From: Simon Davis
Sent: 20 August 2019 10:00
To: Planning.Responses
Cc: Laura Gibbons
Subject: BR/126/19/DOC 65c Gravits lane
Attachments: Front & Rear Soakaway Construction - 65c Gravits Lane.pdf; scan_20190819133307.pdf

Subject: BR/126/19/DOC 65c Gravits lane

I have now reviewed the further information submitted and have provided *comments* next to my original responses below.

LOCATION PLAN
65C GRAVITS LANE BOGNOR REGIS

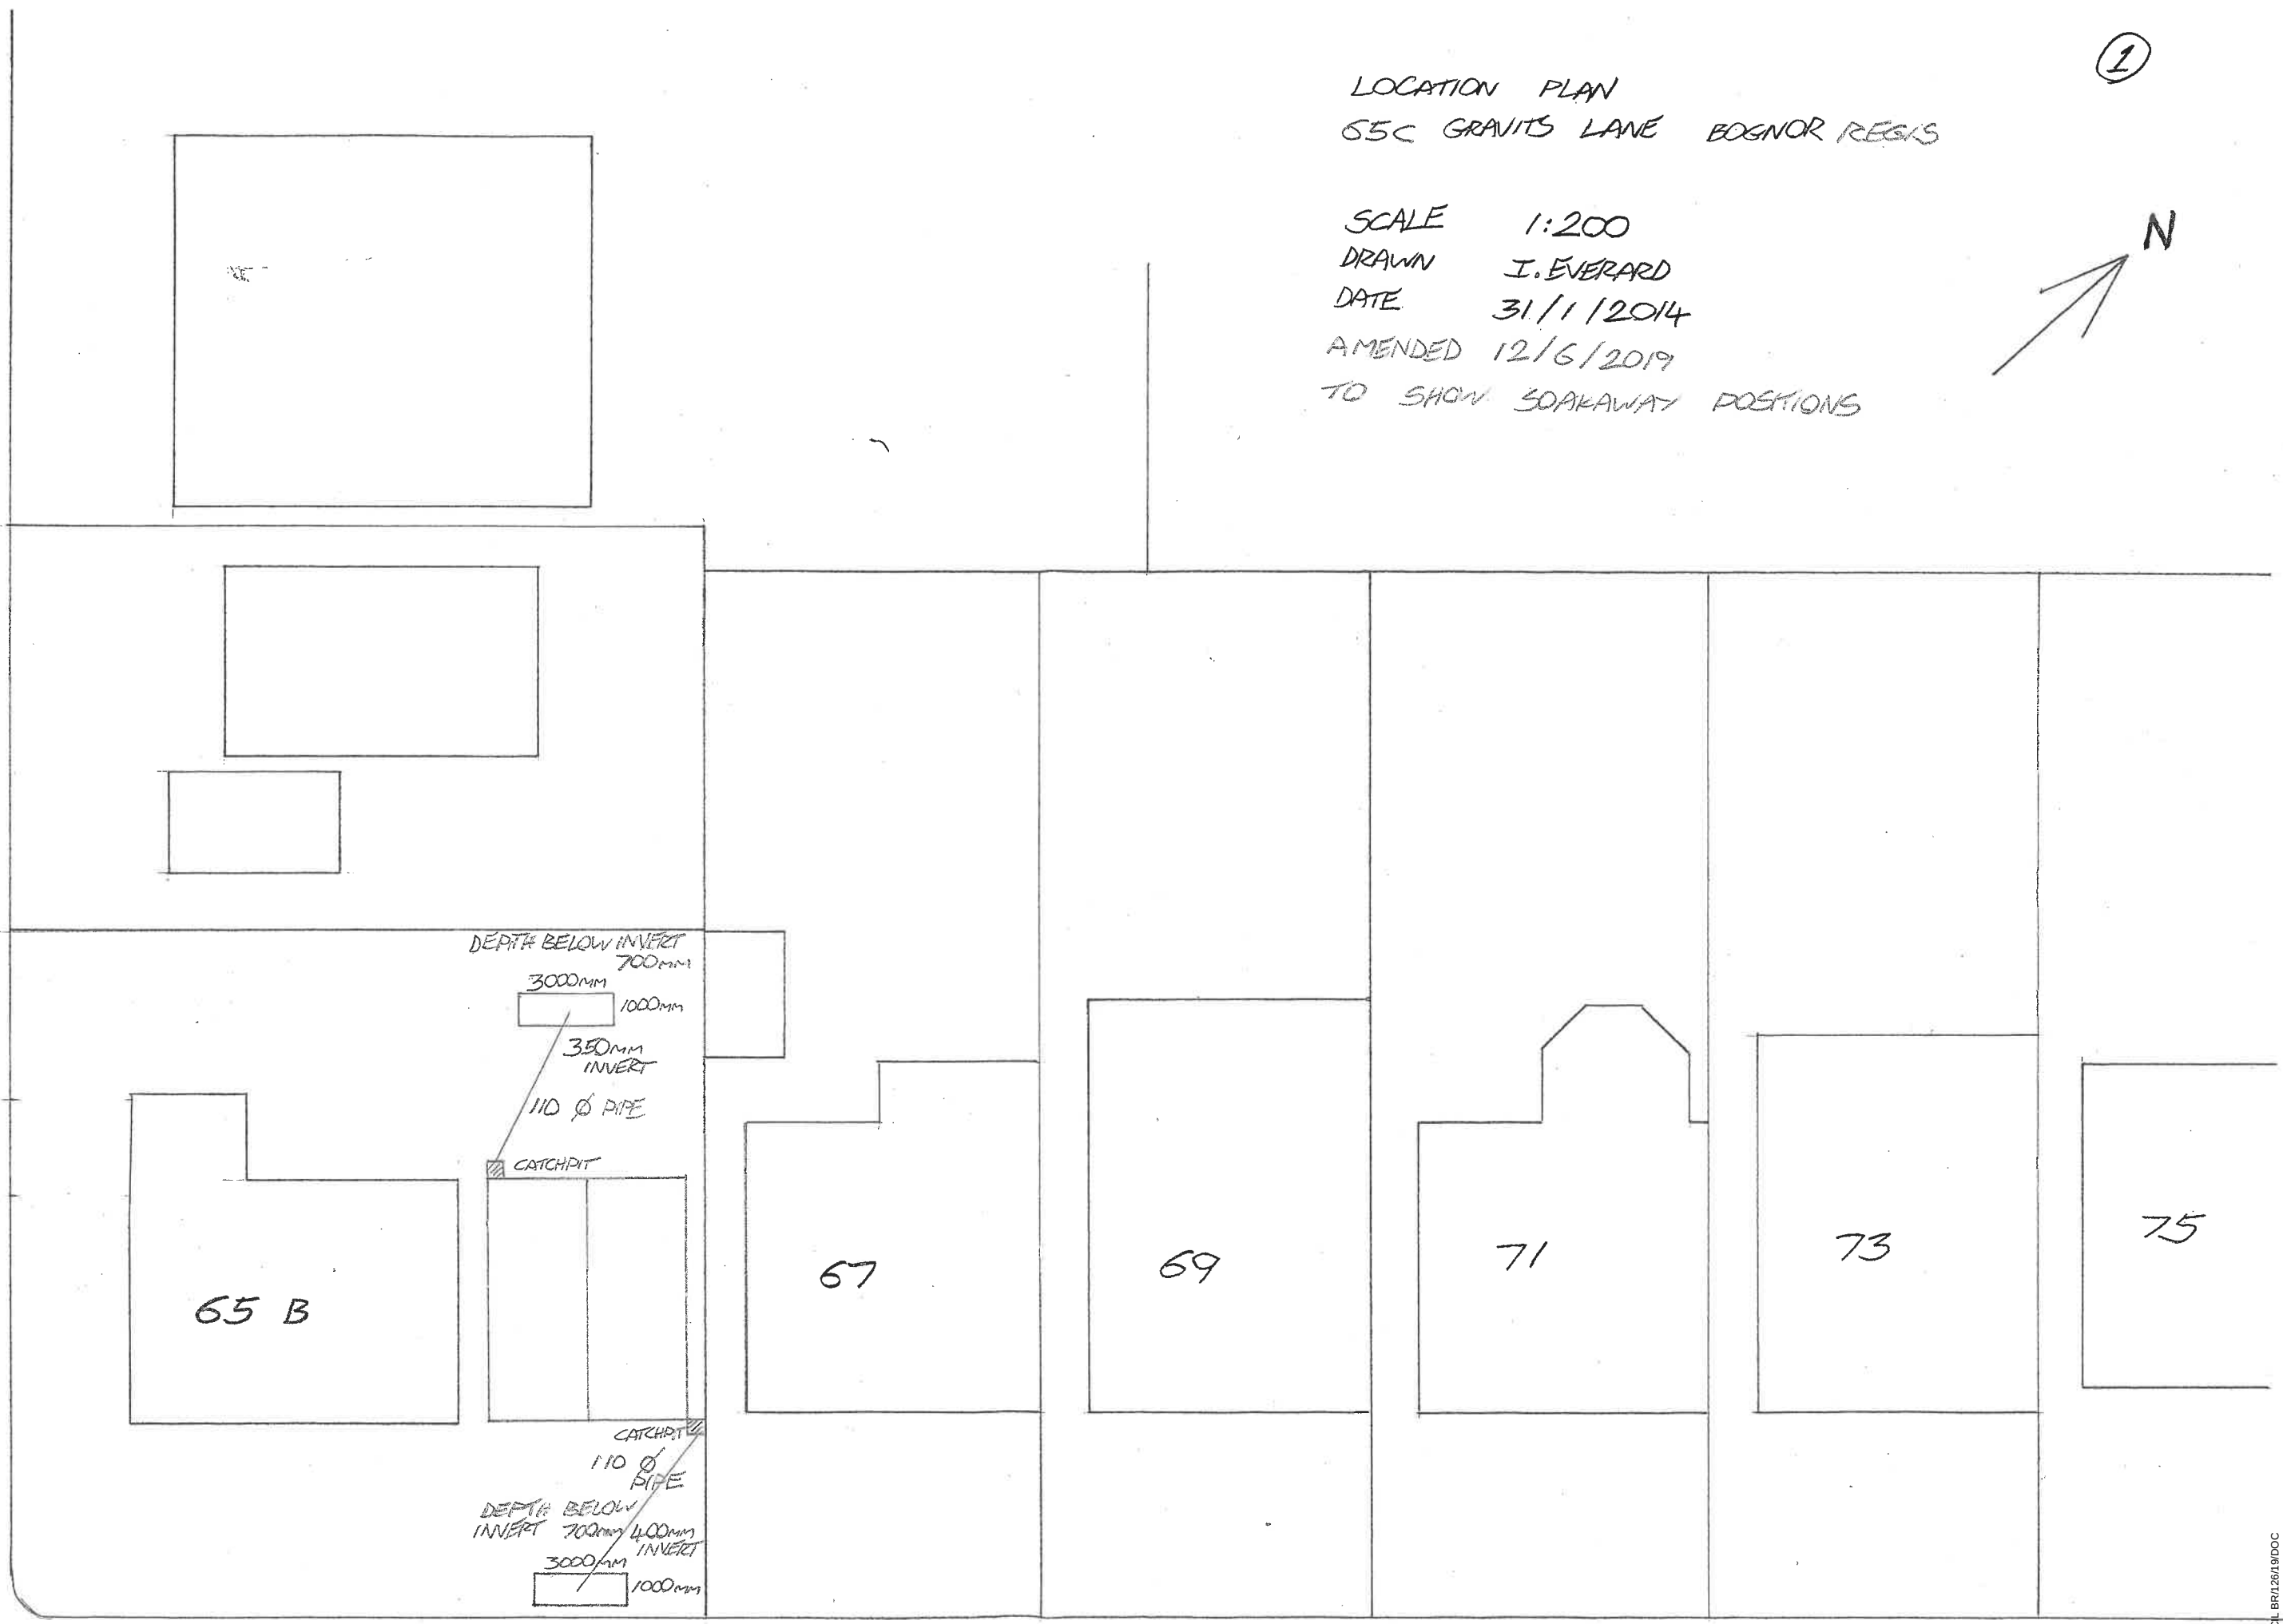
4. The drainage layout plan does not provide the level of detail which I requested on the 13th June. I.e. location and dimensions of pipes, catchpits and soakaways. Diameters, invert levels, cover levels and falls need to be provided. *Okay.*
5. Construction details of catch pit manholes also still have not been provided. *Okay.*

FRONT AND REAR SOAKAWAY CONSTRUCTION
FOR G5C GRAVITY LANE BODNOR REG'S
W. SUSSEX

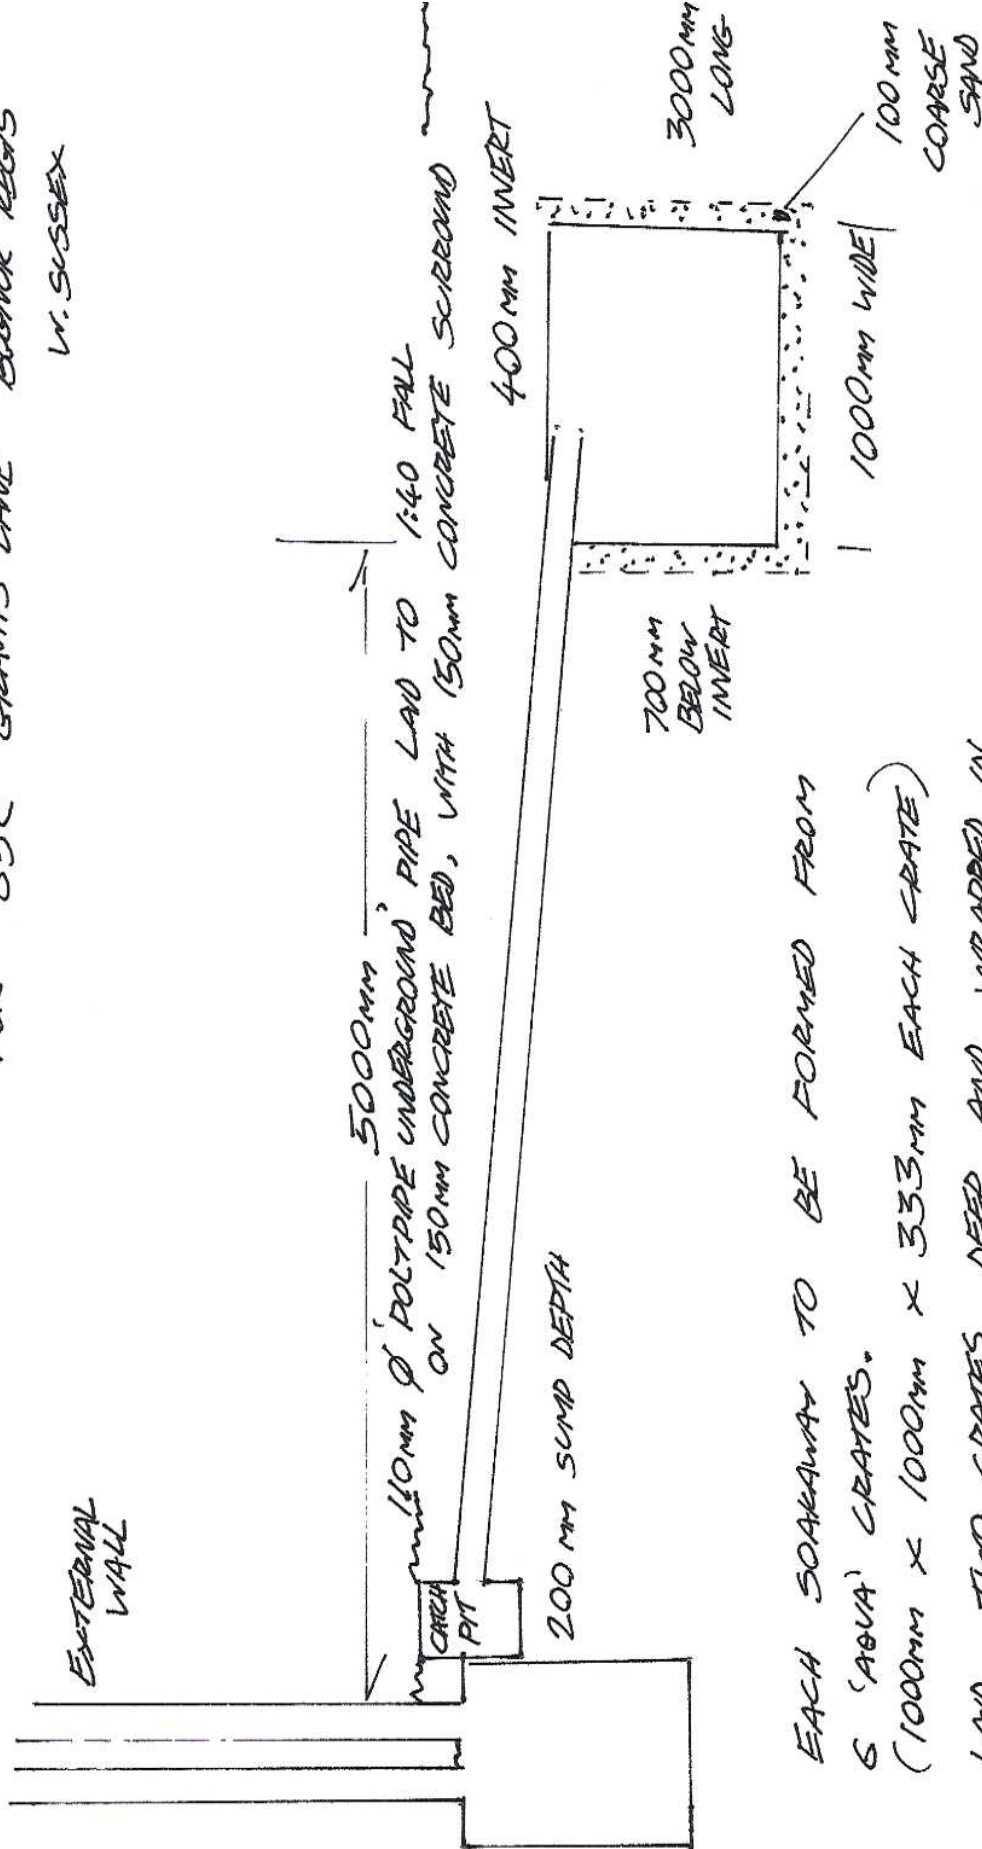
3. Construction details have not been provided. *The cross section detail drawing needs to be updated to state that the pipe will have 150mm concrete bed and surround rather than shingle. And 100mm coarse sand bed*

and surround needs to be provided to the crates (outside of the geotextile wrap).

INFILTRATION CALC'S
LAND ADJACENT TO
65B GRAVITY LANE
BOGNOR REGIS

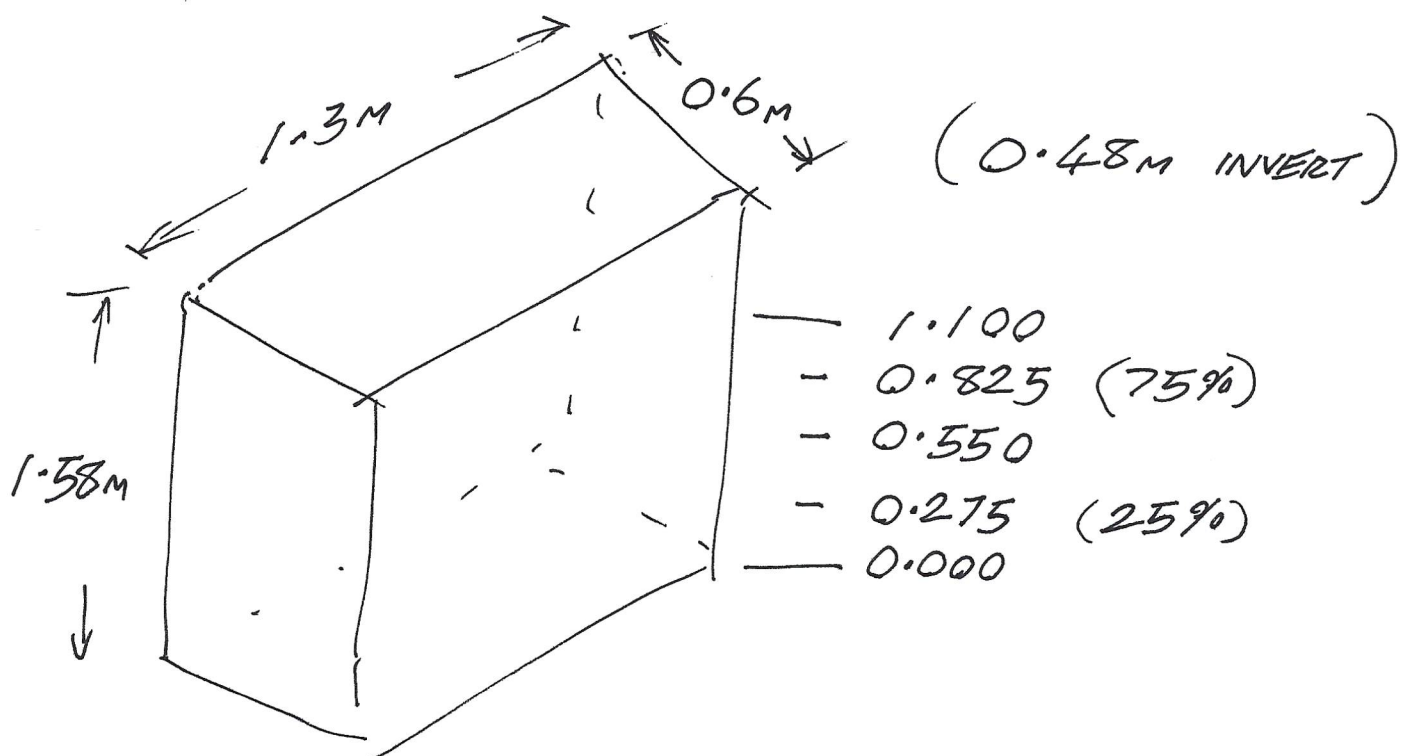
1. The applicant has supplied information regarding groundwater levels and infiltration test results. Both of these were from July 2014, subsequent observations were made and notes indicate no groundwater was observed. However, this does not meet our requirements for winter infiltration testing. *Winter infiltration date has been specified, but no actual test results have been supplied and it is unclear if three repeat tests were completed.*
